**WELWYN HATFIELD BOROUGH COUNCIL  
EXECUTIVE DIRECTOR - PLANNING, PUBLIC PROTECTION AND GOVERNANCE**

**DELEGATED APPLICATION**

**Application No:** 6/2018/0383/FULL  
**Location:** 8 Hill Rise Cuffley Potters Bar EN6 4EE  
**Proposal:** Erection of a three storey detached house with a raised patio following demolition of existing dwelling  
**Officer:** Mr David Elmore

1 Proposed Site 3D View 1

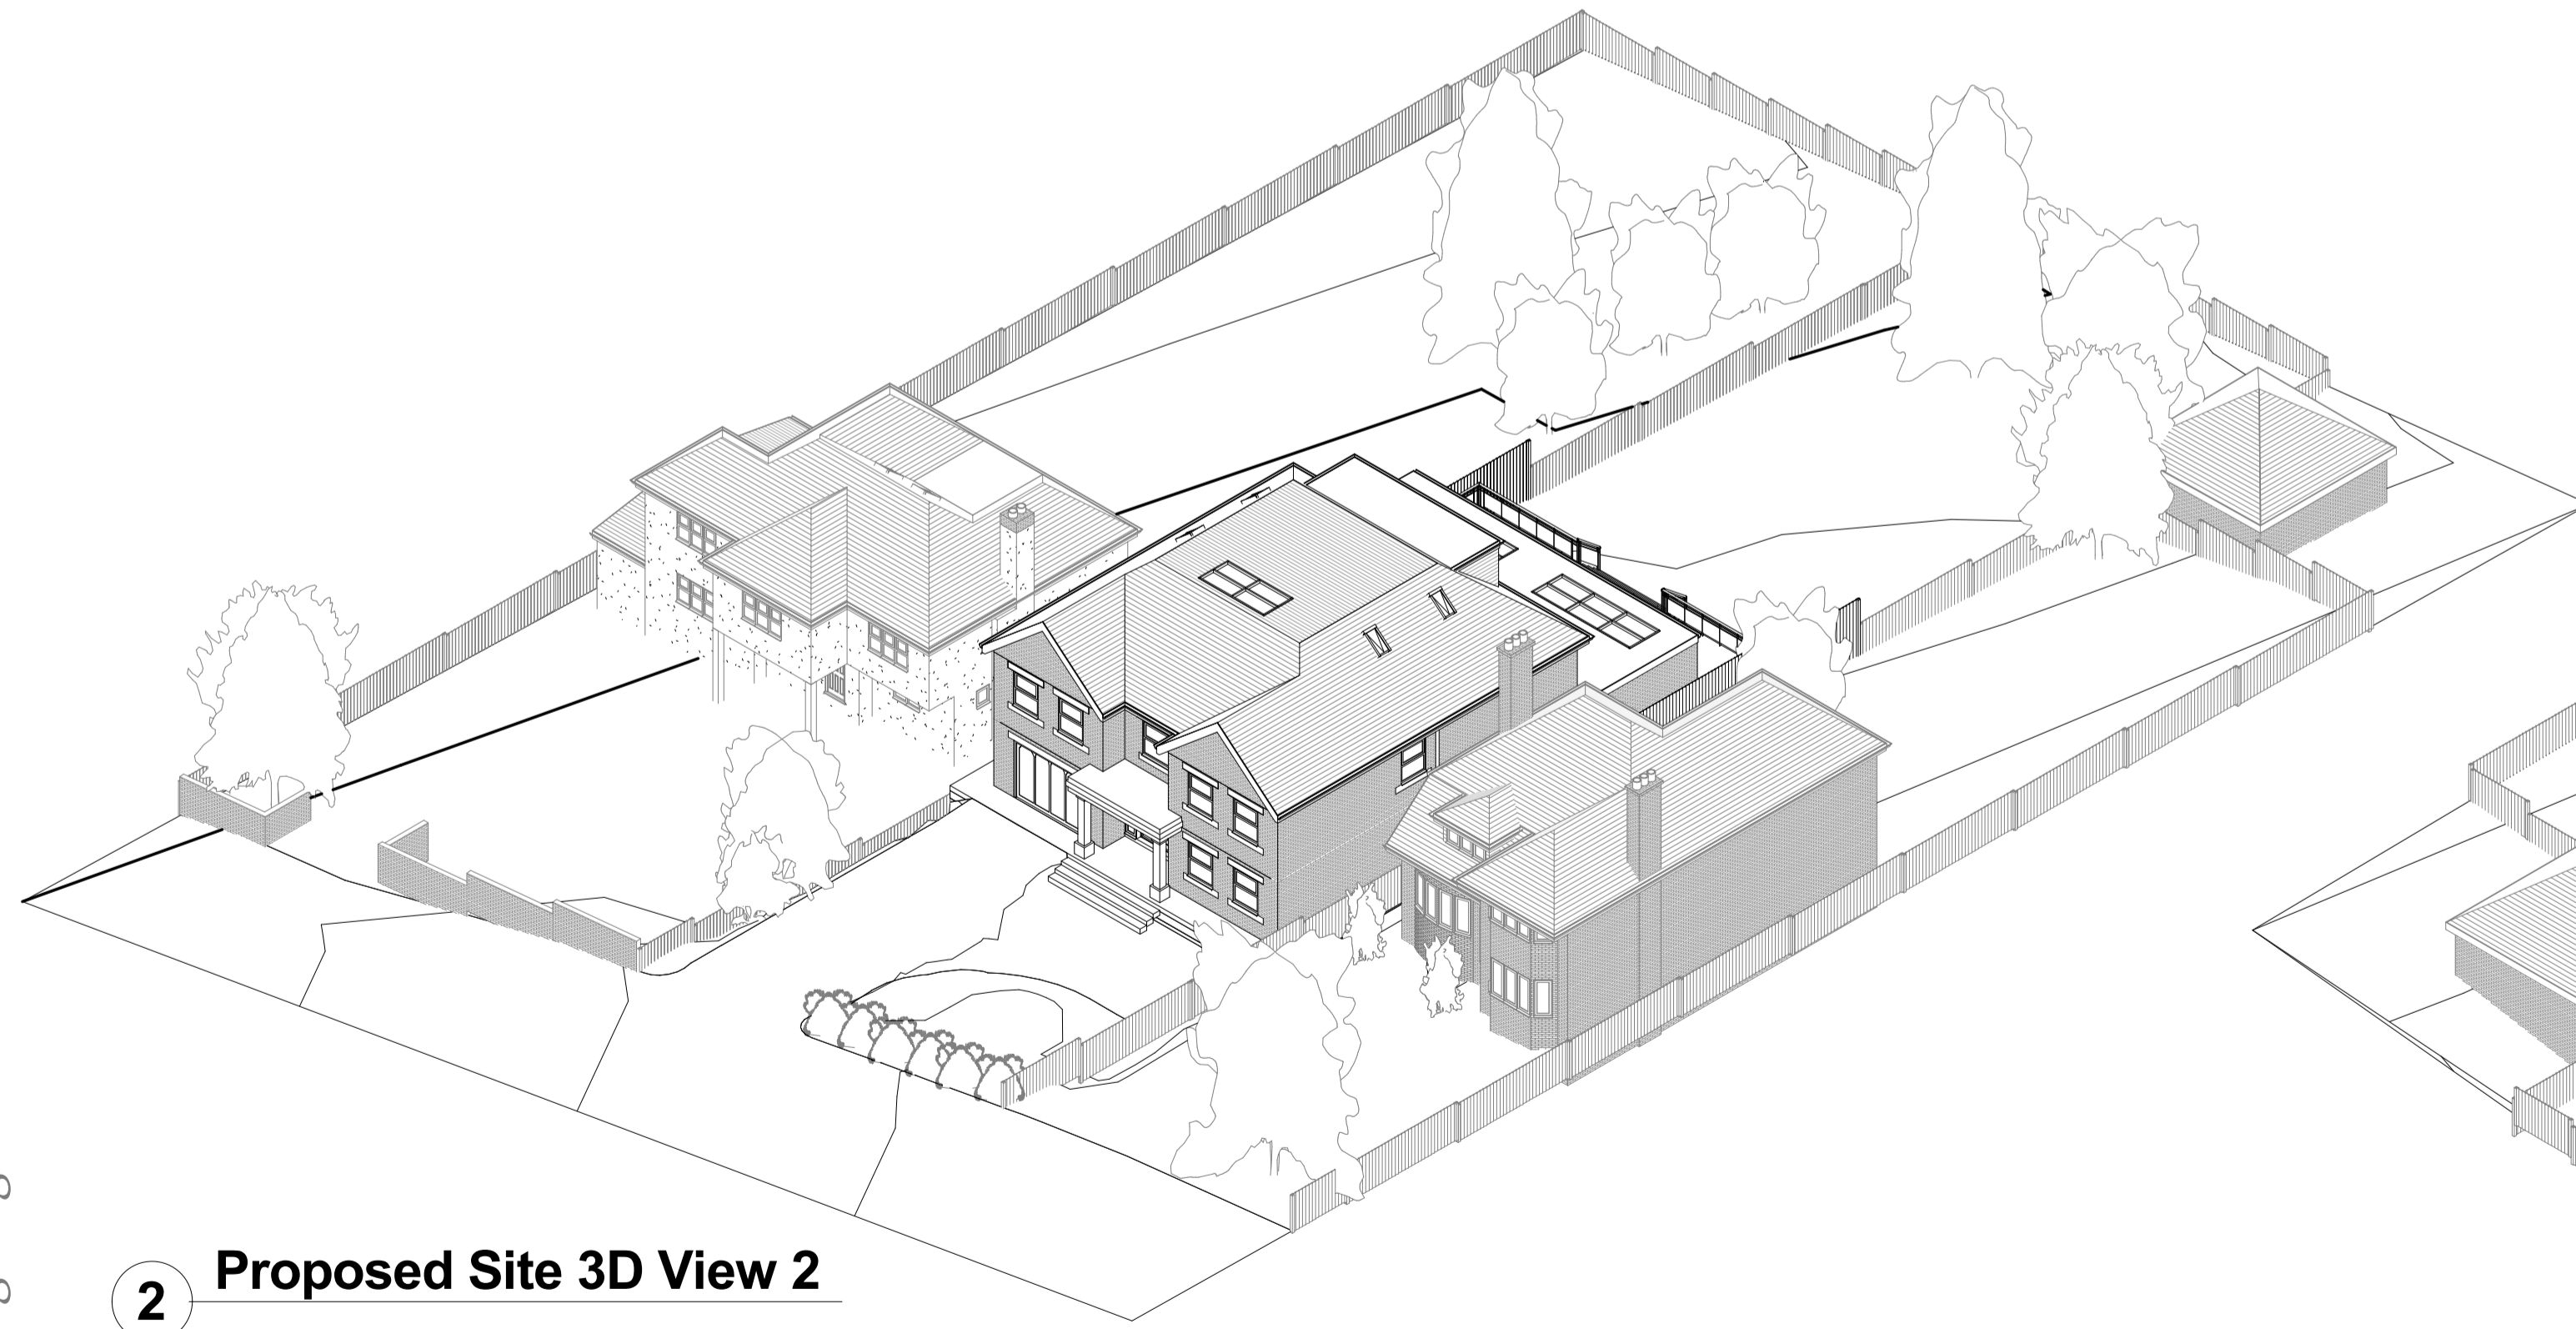
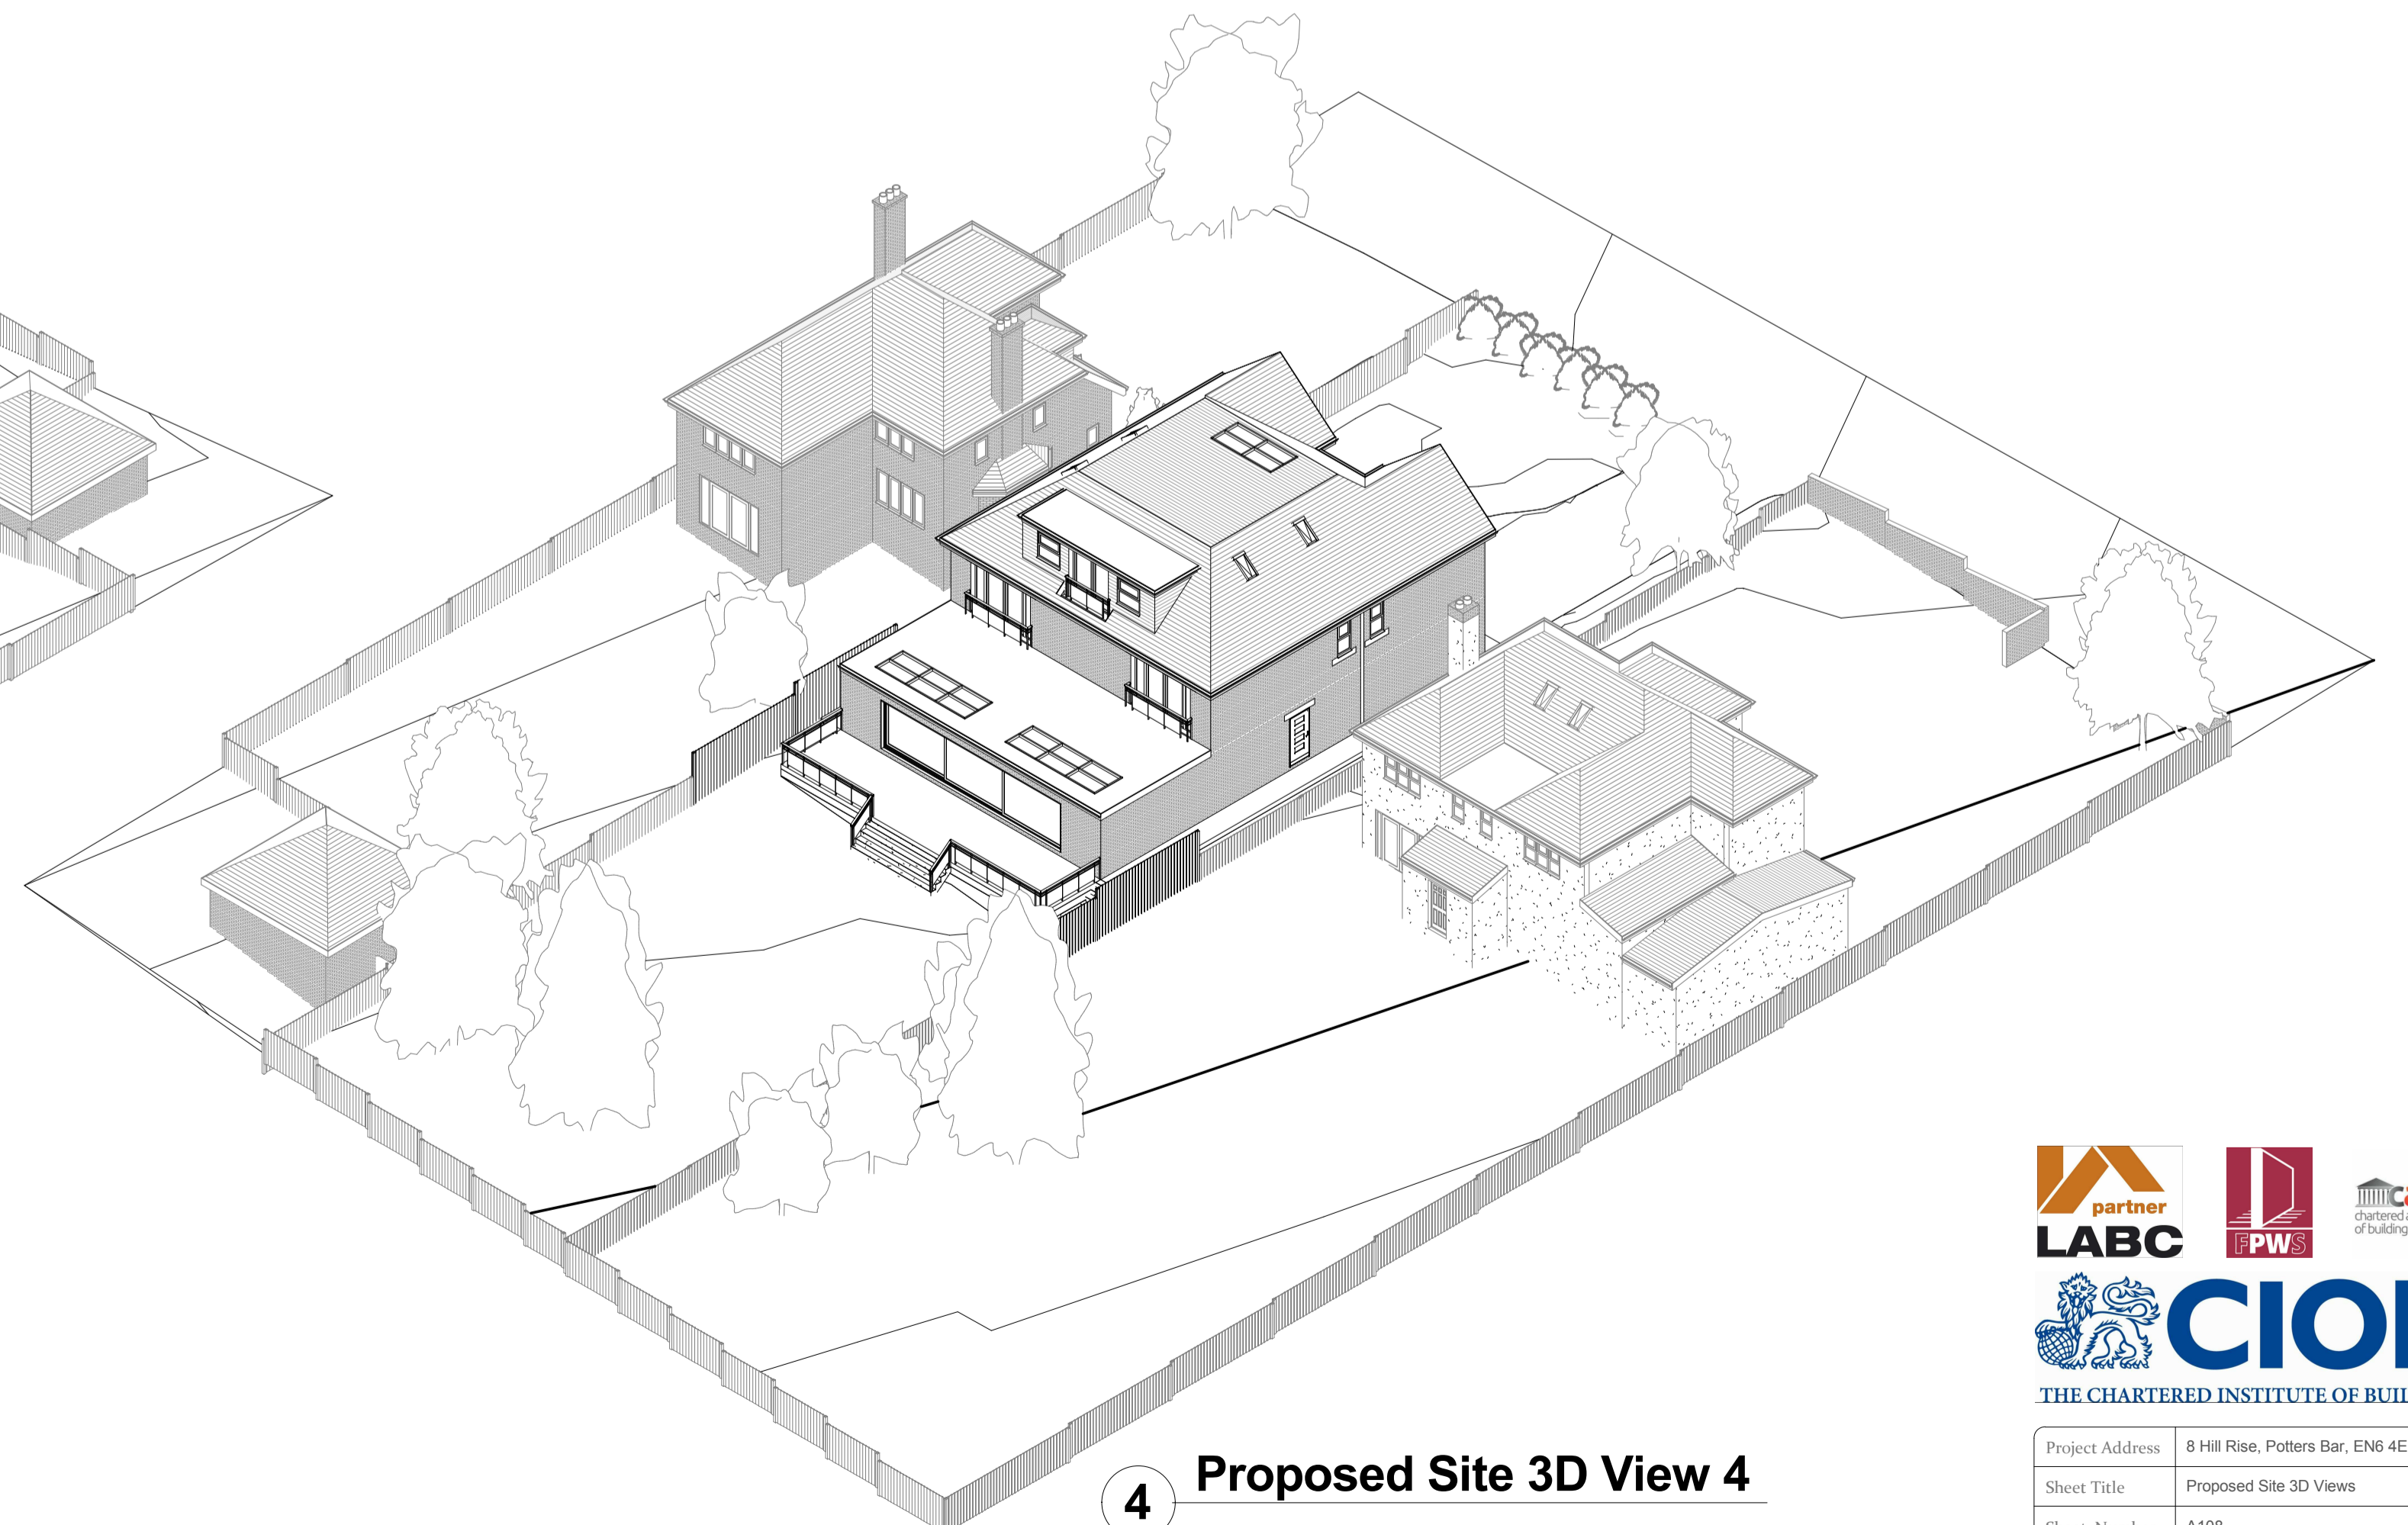
**Comment:** The proposed site 3D views appears to illustrate that the existing front driveway would be retained, however this is not clear.

The proposed dwelling would serve 5 bedrooms. A 5-bed dwelling in location is expected to accommodate a guideline level of 3 off-street car parking spaces having regard to the Council's SPG and Interim Parking Policy. The existing driveway could practically accommodate two cars and the proposed dwelling features an integral garage for one car. In any event, the extent of hard

landscaping will have to be agreed via a planning condition. On this basis, it is considered that a sensible level of parking provision would be achieved, in accordance with both local and national planning policy.
